Application H11-0389-22
Location Land at Seagate Road Long Sutton Spalding
Proposal Details of scheme to deal with contamination, construction management plan, levels, landscaping, boundary treatments, external materials and meter boxes (Conditions 3, 5, 6, 8, 9, 10 & 11 of H11-0882-21)

Name Sue Armour
Address Environmental Protection Officer SHDC

Date Submitted 09-06-22
For/Against Comments

1. Do not scale
2. Locations of all features are approximate only
3. Background image taken from Templeman Design drawing number 3359-TD-XX-DRG-AR-0002-PO, dated November 2017 – shows proposed development

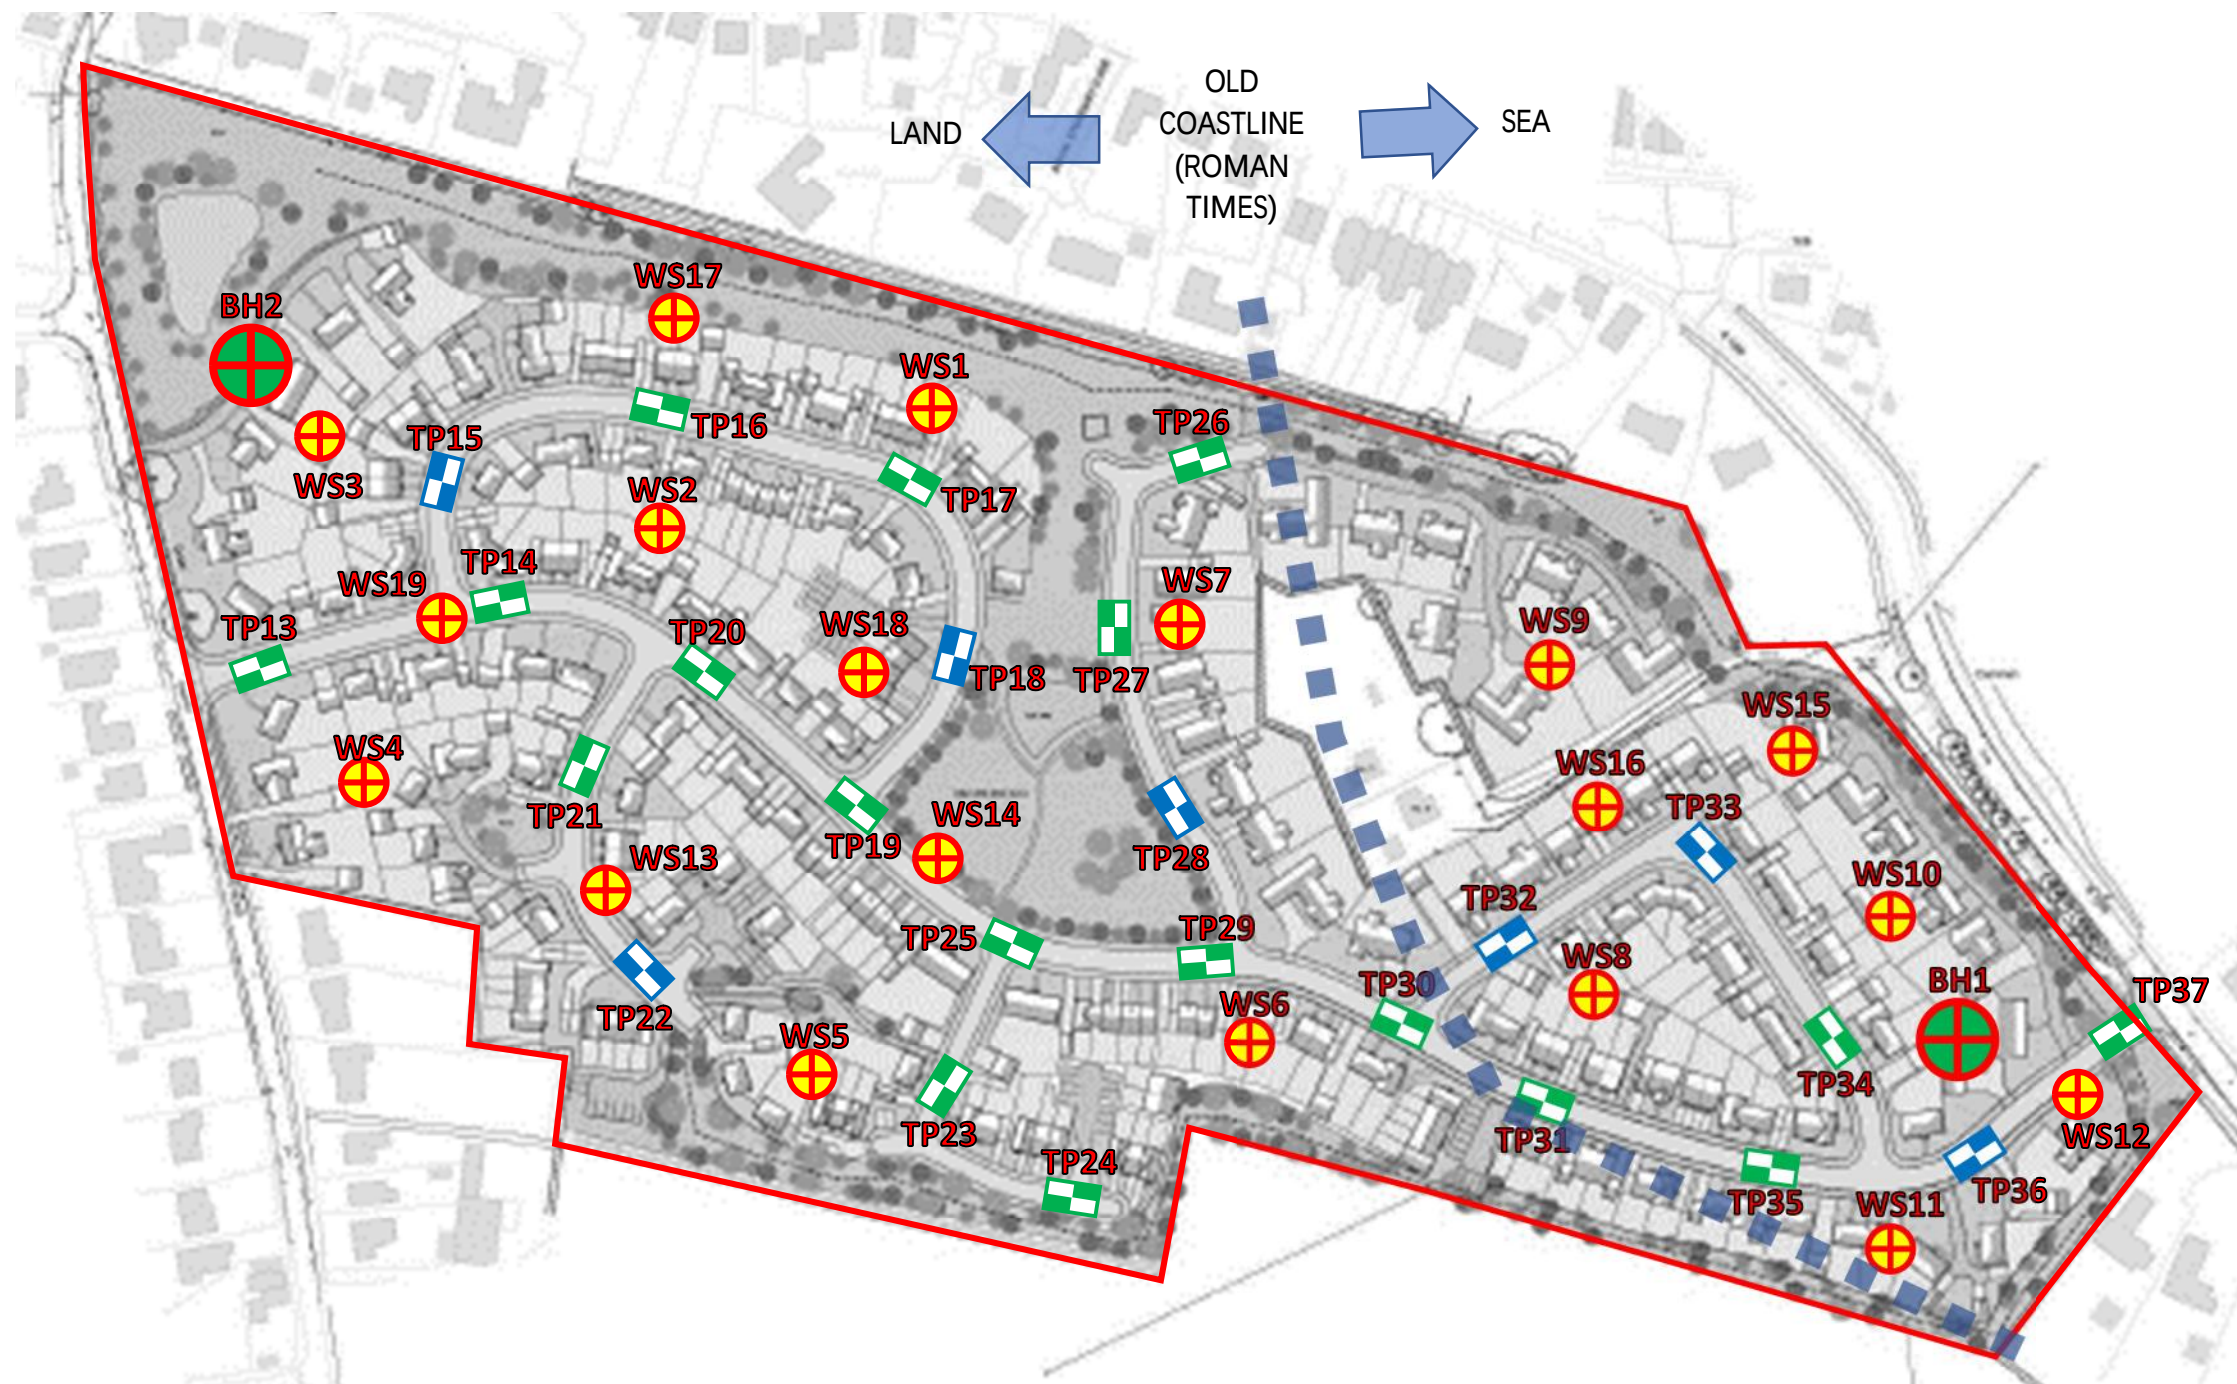
Whilst I am in general agreement with the findings, the report does not identify the former running lines and signal point of the railway which used to run through the northern part of the site as a potential source of contamination. There was subsequently no site investigation in this area, either in the current redline boundary or in the larger area covered by the report, to know if all the material used to make up the track bed was removed. Track beds can contain elevated levels of fuels and poly aromatic hydrocarbons as well as metals. Looking at the current development plan (LDC-3598-PL-12 C Proposed Site Plan) please can some clarification as to the nature of the proposed land use in this area be given and this be considered in the context of the conceptual model?
